## London Borough of Hillingdon

### COMMENTS ON EXA'S SECOND WRITTEN QUESTIONS

#### HIGHWAYS ENGLAND'S RESPONSE

Figure 1: NO₂ Projections Informing IAN 170/12 v3

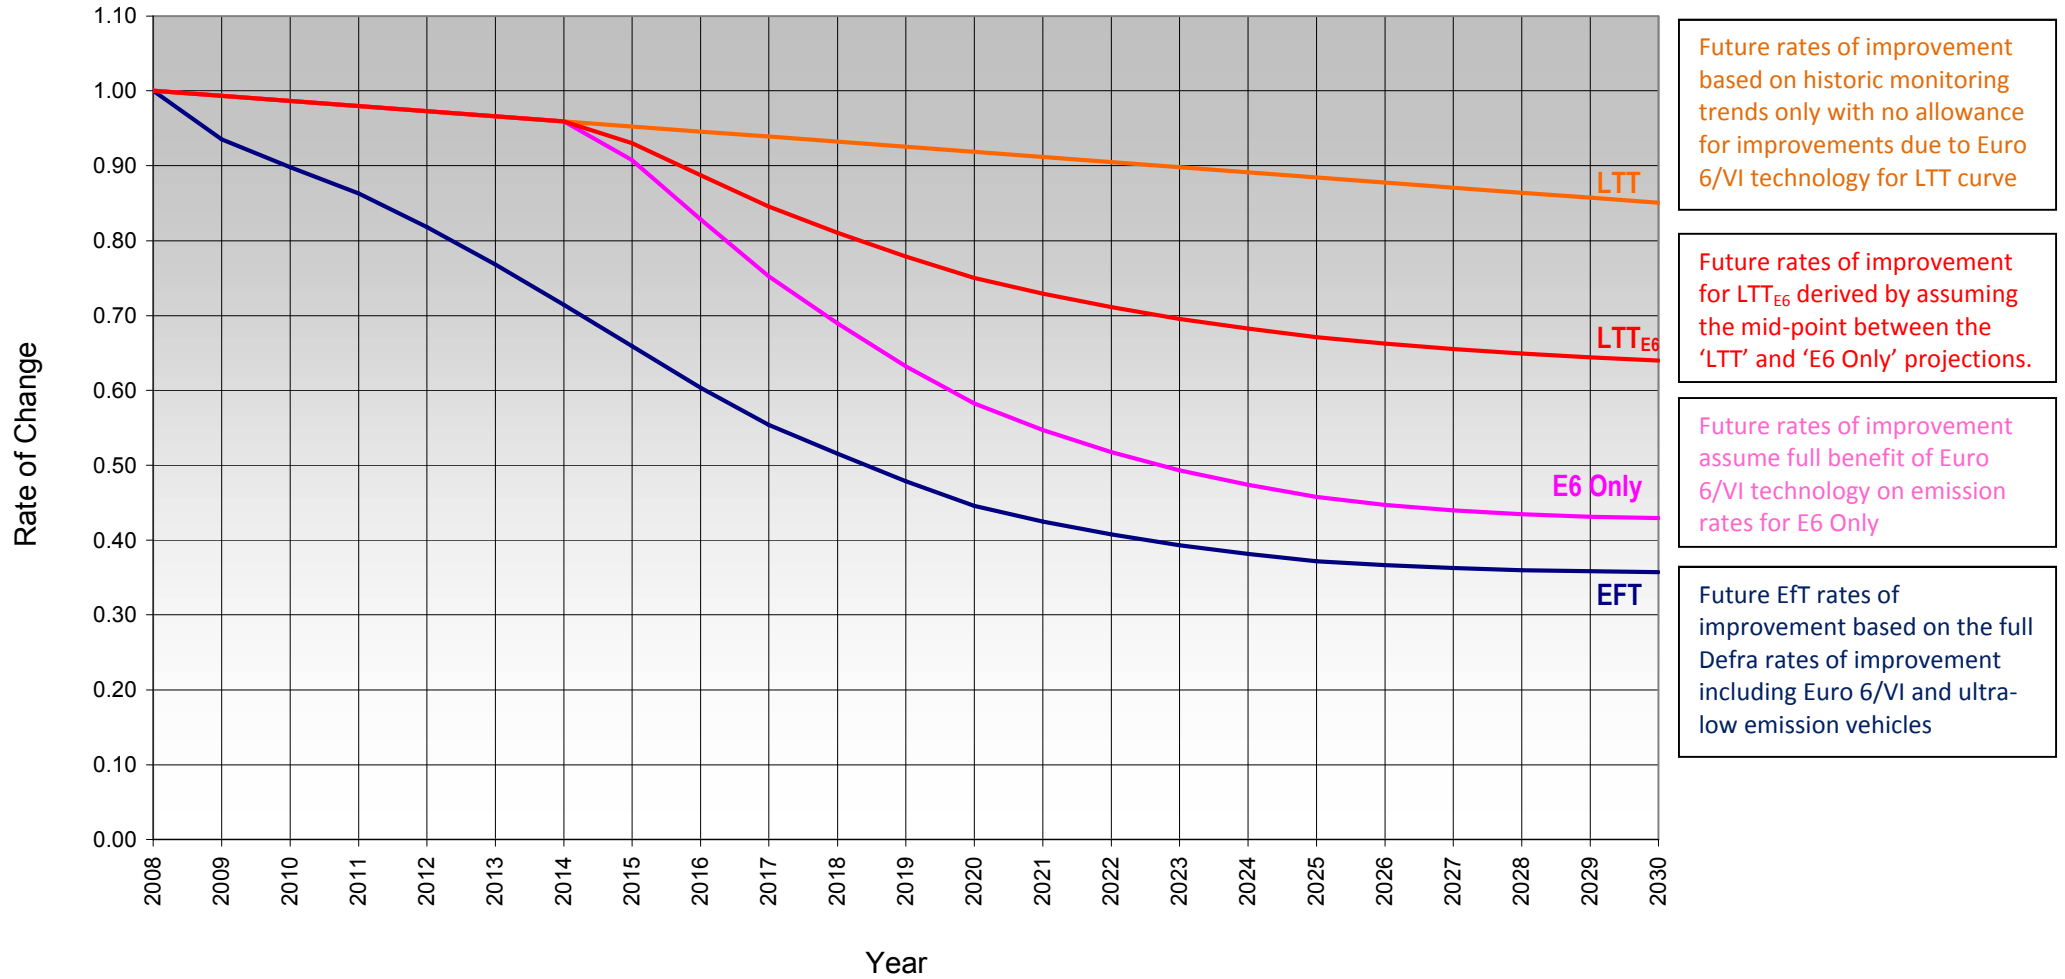
<p>4.6.4</p>	<p>Various references are made in this section to the use of the LTT<sub>E6</sub> results providing a more conservative assessment than the Defra projections. The basis of the LTT<sub>E6</sub> results is illustrated in the graph presented by HE to the ExA at the November Hearings (Appendix E – Derivation of LTT<sub>E6</sub> Used in the Environmental Statement). No further details have been provided by HE on the derivation of the curves in this Figure, despite requests. It is understood that the LTT<sub>E6</sub> results have been arbitrarily chosen to lie half way between those of the original LTT approach (the trend from monitoring data) and the E6Only approach, which assumes that Euro 6/IV vehicles deliver as expected. In practice, it would be expected that the E6Only approach would equate to the use of Defra’s EFT which assumes Euro 6/IV vehicles deliver as expected. This expectation is not however borne out in the results presented by HE in the ES. To take an example based on the results for receptor X9 (all values presented are base values, without scheme, as presented in the ES, i.e. not calibrated against the AURN alone, which would give higher values): the nitrogen dioxide concentration in 2013 is 46.8 g/m<sup>3</sup>, in 2022 the concentration using the EFT becomes 34.4 g/m<sup>3</sup> and 36.2 g/m<sup>3</sup> with the LTT<sub>E6</sub>. Using the LTT approach the 2022 value would have been 43.8 g/m<sup>3</sup>. If the logic of the LTT<sub>E6</sub> worst-case approach were to apply the value should fall halfway between 43.8 g/m<sup>3</sup> and 34.4 g/m<sup>3</sup>, i.e. 39.1 g/m<sup>3</sup>, not 36.2 g/m<sup>3</sup>. HE does not seem to be applying the logic underlying its recommendation to use LTT<sub>E6</sub> as a worst case approach. It therefore appears to be underestimating the ‘worst-case’ concentrations, further emphasising the risk that future concentrations may be higher than assessed.</p>	<p>The E6Only curve and the Defra EFT curve are not the same, as shown on Figure 1 'Rates of NO<sub>2</sub> Change Informing IAN 170/12v3' included in Highways England's response to the London Borough of Hillingdon's written representation at Deadline V (REP5-005).</p> <p>The approximate calculations undertaken here by the London Borough of Hillingdon overly simplify the LTT calculation and are based on total concentrations predicted at receptors following the LTT and EFT methodologies.</p> <p>As previously explained, the LTT curve does not include the anticipated benefits of Euro 6/VI technology which, in the opening year of the Scheme, is projected to be a significant component of the vehicle fleet with the associated reductions in emissions. Therefore, it would be inappropriate and inaccurate to use a LTT curve which is not capable of reflecting reductions in emissions and associated pollutant concentrations.</p> <p>As such, it is considered that the LTT projection is overly pessimistic, and would not represent a realistic worst case scenario as is required by law and as described in Advice Note Nine: Rochdale Envelope, page 8 “<i>The EIA should assess the likely worst case in terms of the potential variations within a project but the detailed design of the project and the variations should not vary beyond these limits so that the</i></p>
